From: Kate Giddings <kate.giddings@arun.gov.uk>
Sent: 26 November 2019 16:13
To: Simon Davis <Simon.Davis@arun.gov.uk>
Cc: Planning.Responses <Planning.Responses@arun.gov.uk>
Subject: Y/101/19/DOC - Yapton View (land off Burndell Road), Yapton, BN18 0HW

In relation to the above application, I understand from the submitted documents that Geo-Environmental's Remediation Strategy and Verification Report (ref.: GE18533/RSVR/SEP19, dated September 2019) has been provided with the aim of allowing discharge of condition 3 (remediation strategy) and condition 5 (verification plan). In order for this Department to consider discharging the conditions, please may the following points be addressed:

Plate 1 View of Made Ground excavation with chalk backfill along access route

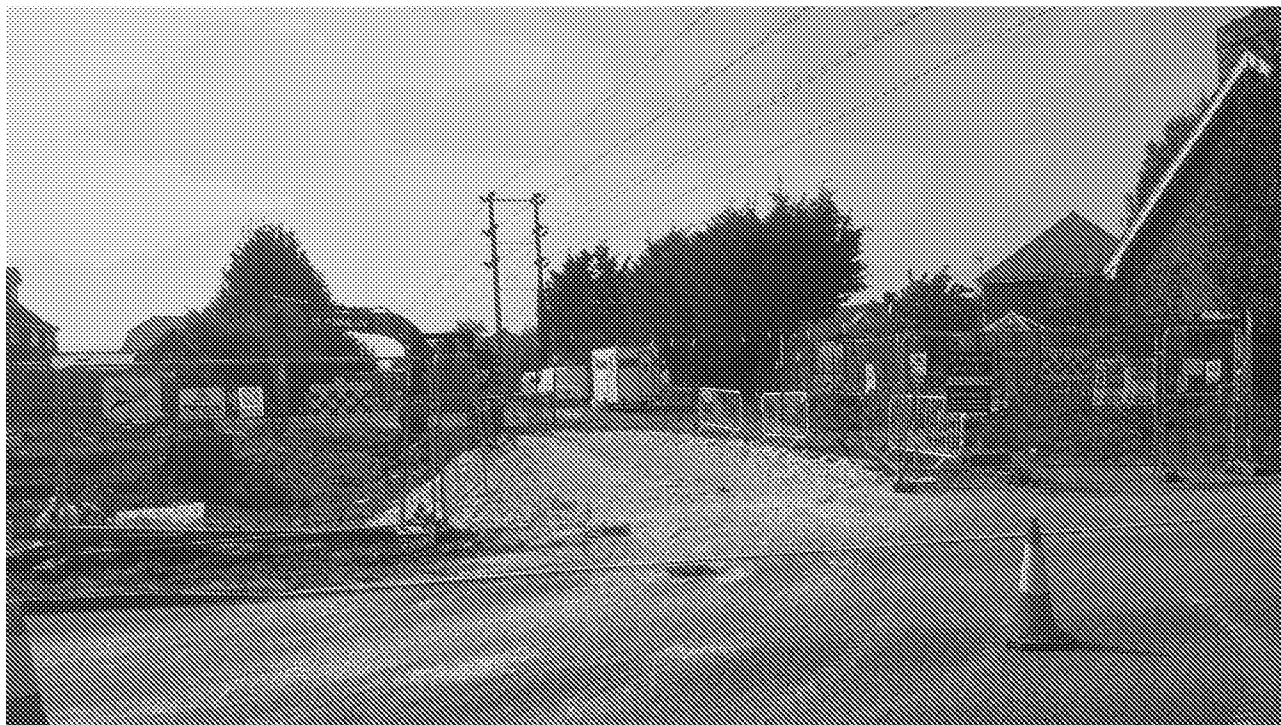
- date(s) of remedial work (it is noted that the visit to confirm the mass excavation was 15 April 2019)
- provision of the post-excavation validation sampling
- evidence of removal of material from site to a suitable facility (hazardous waste)
- evidence of the membrane placement
- evidence of material imported to site
